**KIRKLEES METROPOLITAN COUNCIL
INVESTMENT & REGENERATION SERVICE**

**DELEGATED DECISION TO DETERMINE APPLICATIONS FOR
CONSENT, AGREEMENT OR APPROVAL REQUIRED BY CONDITION**

Reference No:	2026/44/90381/E
Site Address:	Grange Moor Coachworks, Barnsley Road, Grange Moor, Huddersfield, WF4 4DR
Description:	Discharge of details reserved by conditions 5 (Landscape), 6 (retaining walls/structures), 16 (external lighting), 23 (Noise Impact Assessment) on previous permission 2023/90668 for demolition of existing buildings; erection and operation of single building comprising Sui Generis land use limited to purpose of storage, assembly, sale and distribution of custom-built computers, laptops and their components as well as any associated development (those being replacement wind turbine, utility provision, drainage, access, hard and soft landscaping) within the red-line boundary alongside business operations pursuant to the effective administration of the Sui Generis use
Recommending Officer:	Farzana Tabasum

Application: 2026/90381

Title:
Retaining Walls Site Plan

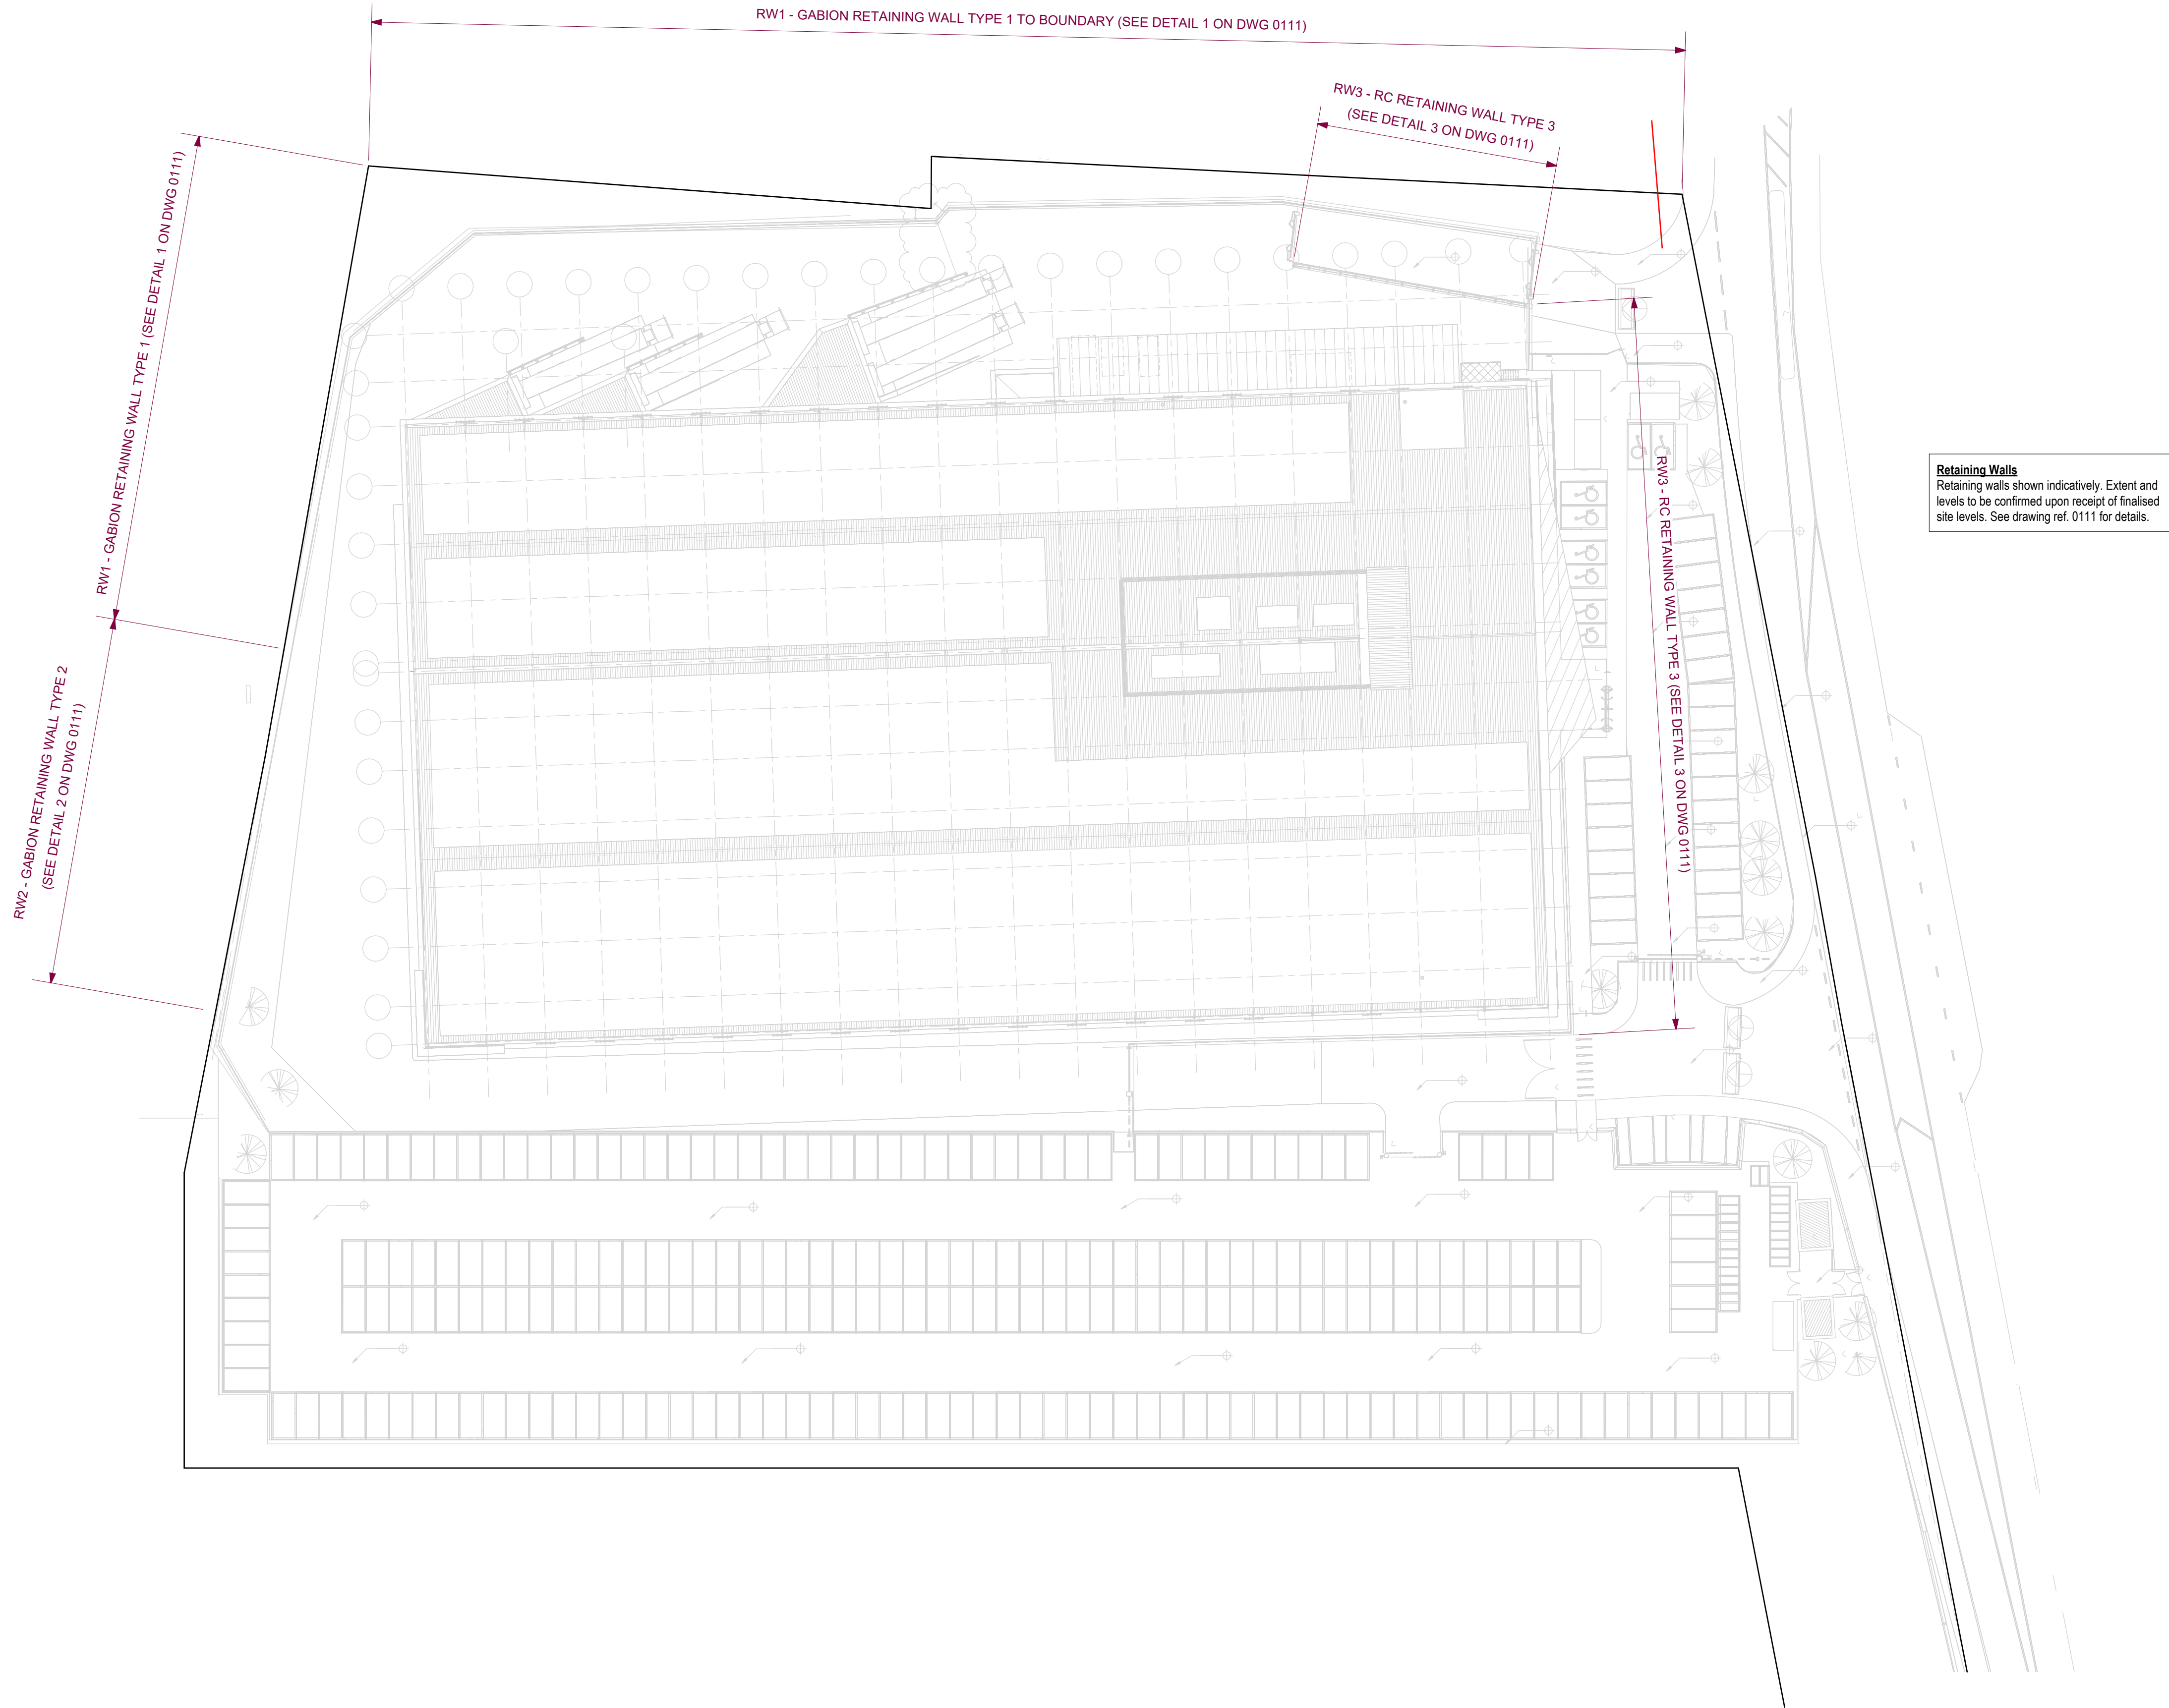
The Avie Consulting drawings (000101-C02 and 000111-C02) provide detailed engineering information for the retaining walls required along the boundary. These drawings include construction methodology, dimensions and structural build-up, demonstrating that level changes can be accommodated wholly within the site without encroachment beyond the red line boundary.

The submitted Avie Consulting drawings provide sufficient detail in relation to retaining wall construction, including geometry, materials and installation. These confirm that the structures can be safely implemented without adverse impacts on adjacent land or infrastructure.

TITLE	SALES & INSTALLATION DRAWING
	JAKOUSTIC FENCING SYSTEM – 3.0m HIGH
CUSTOMER	
ACK No.	
Drawing No.	J7/01043
	Sheet 3

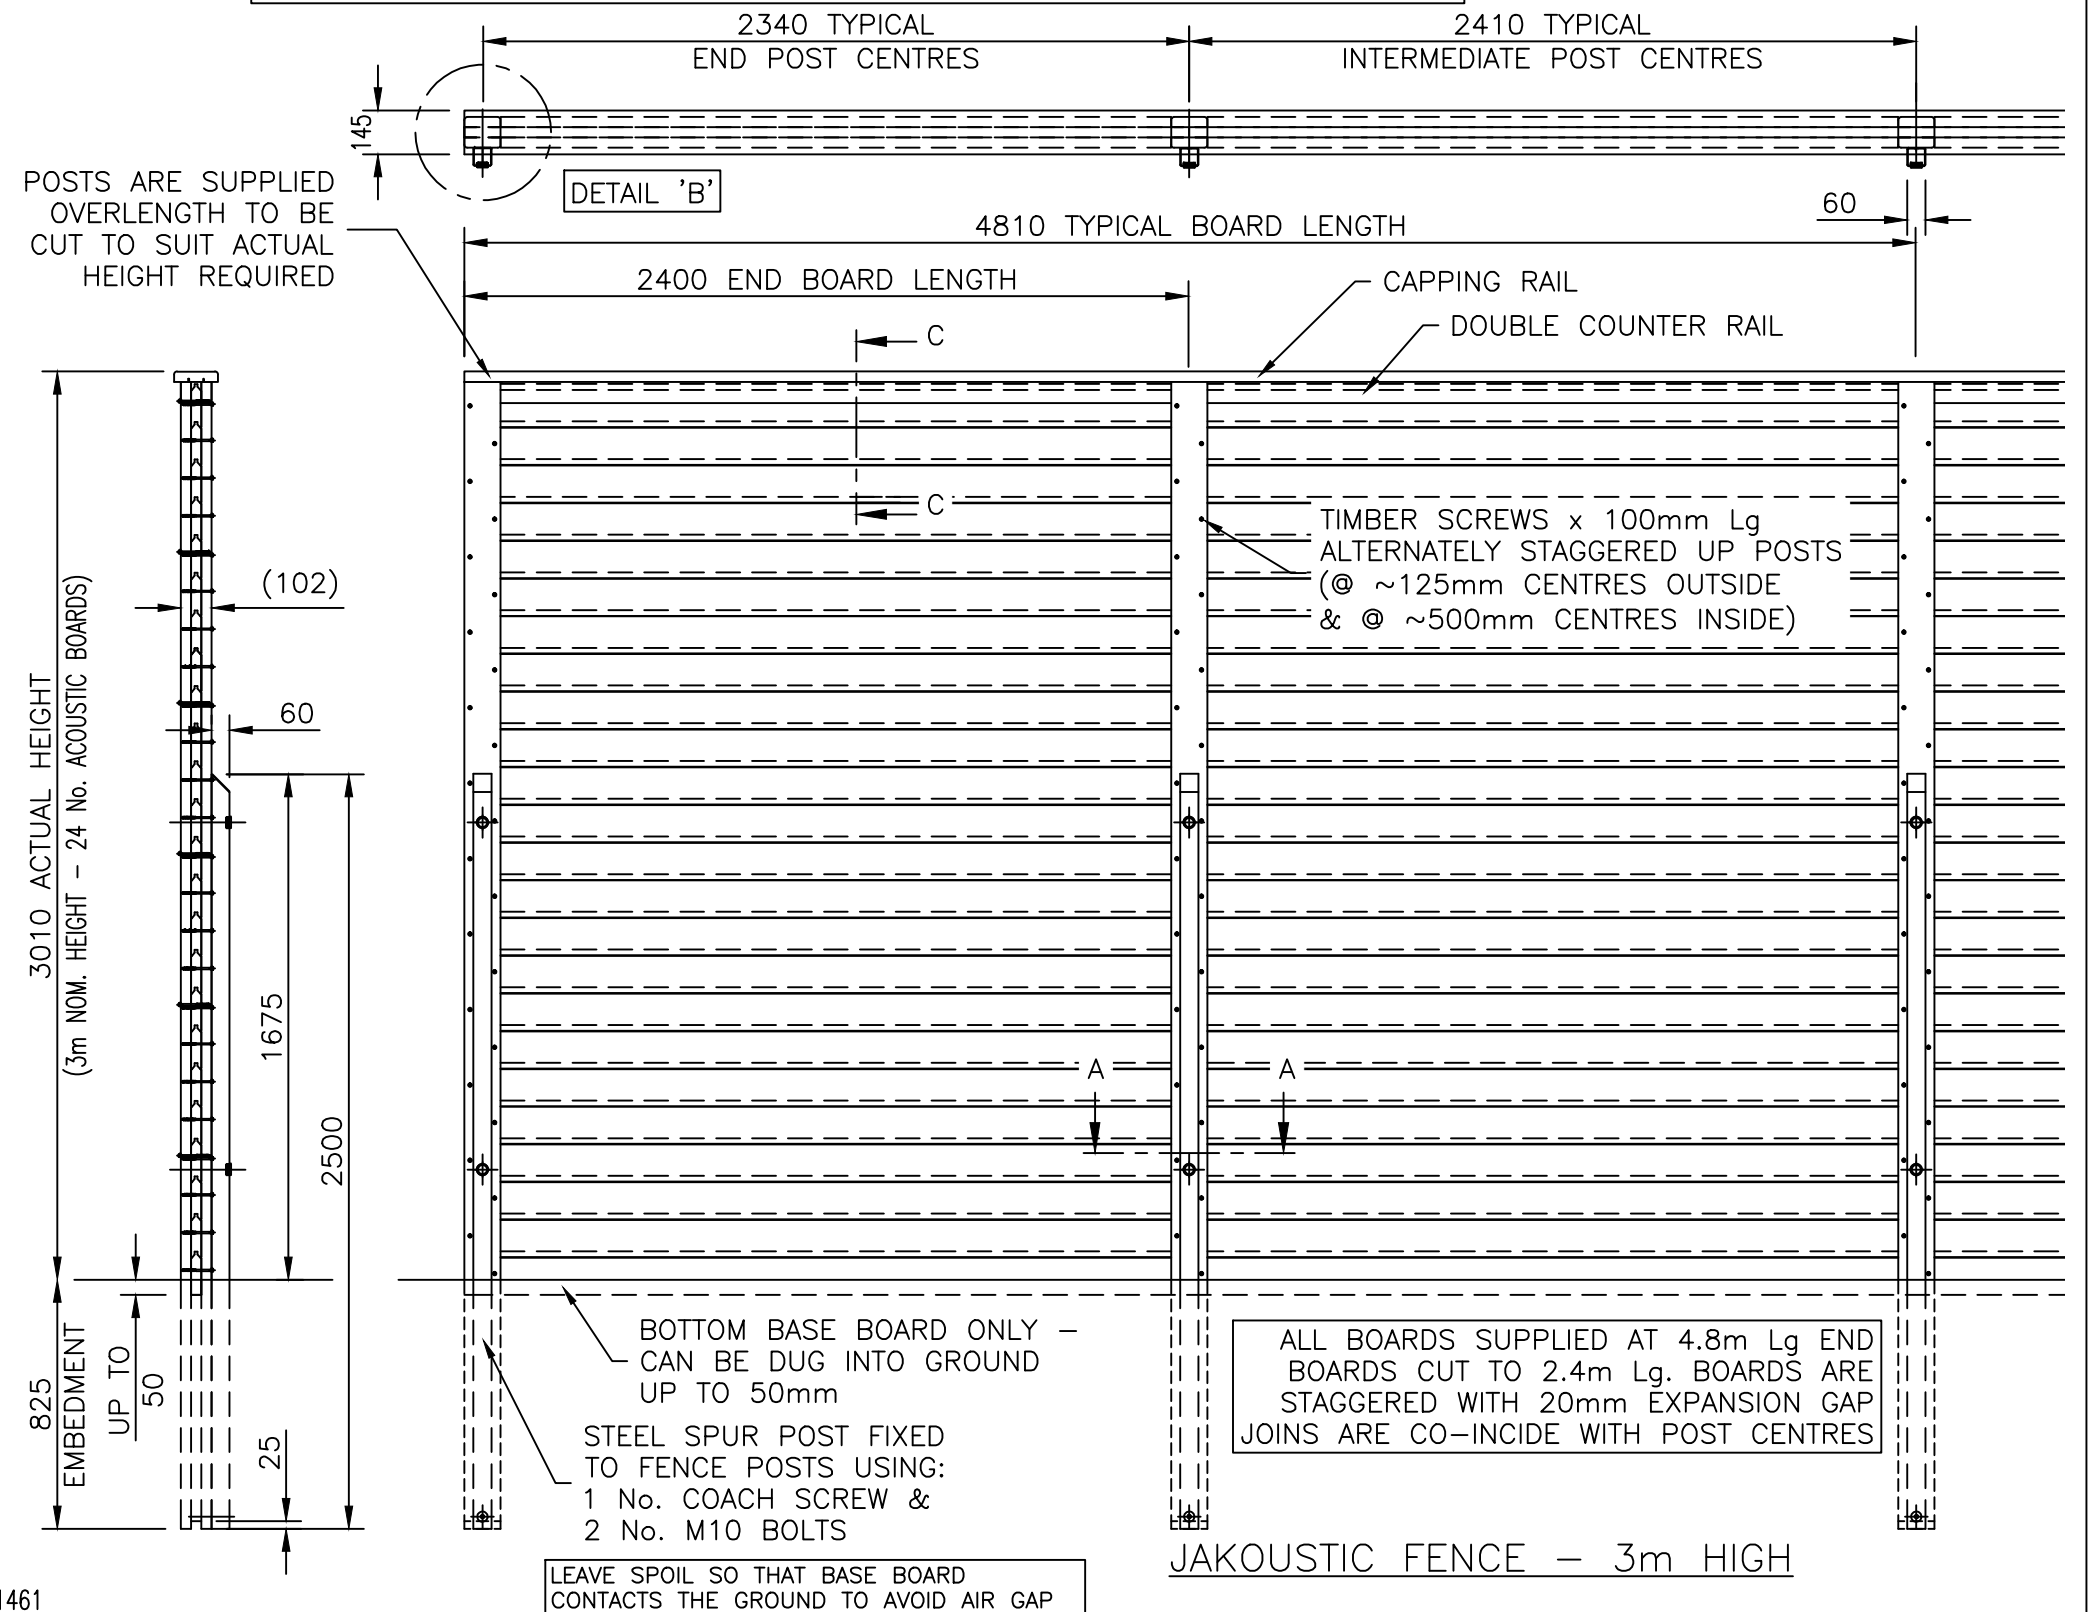
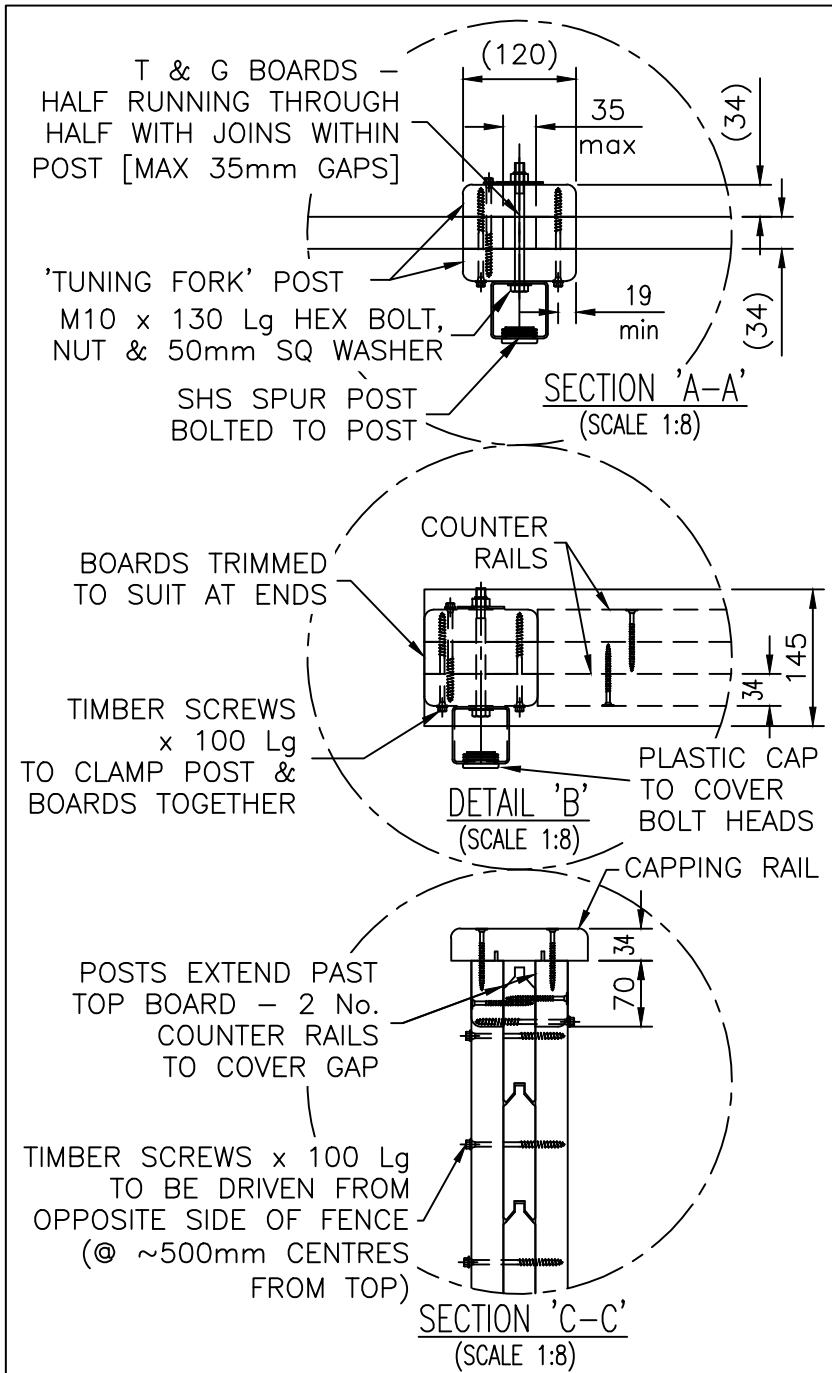
The submitted details confirm a barrier height of 3 metres along the northern boundary, as shown on the approved boundary treatment plan. This height is considered appropriate to achieve effective noise attenuation.

The Jakoustic Reflective system specification provides detailed information on:

- Material composition and acoustic performance;
- Structural support and installation method;
- Interface with ground and continuity of barrier.

These details are sufficient to ensure that the barrier will perform as required to mitigate noise impacts.
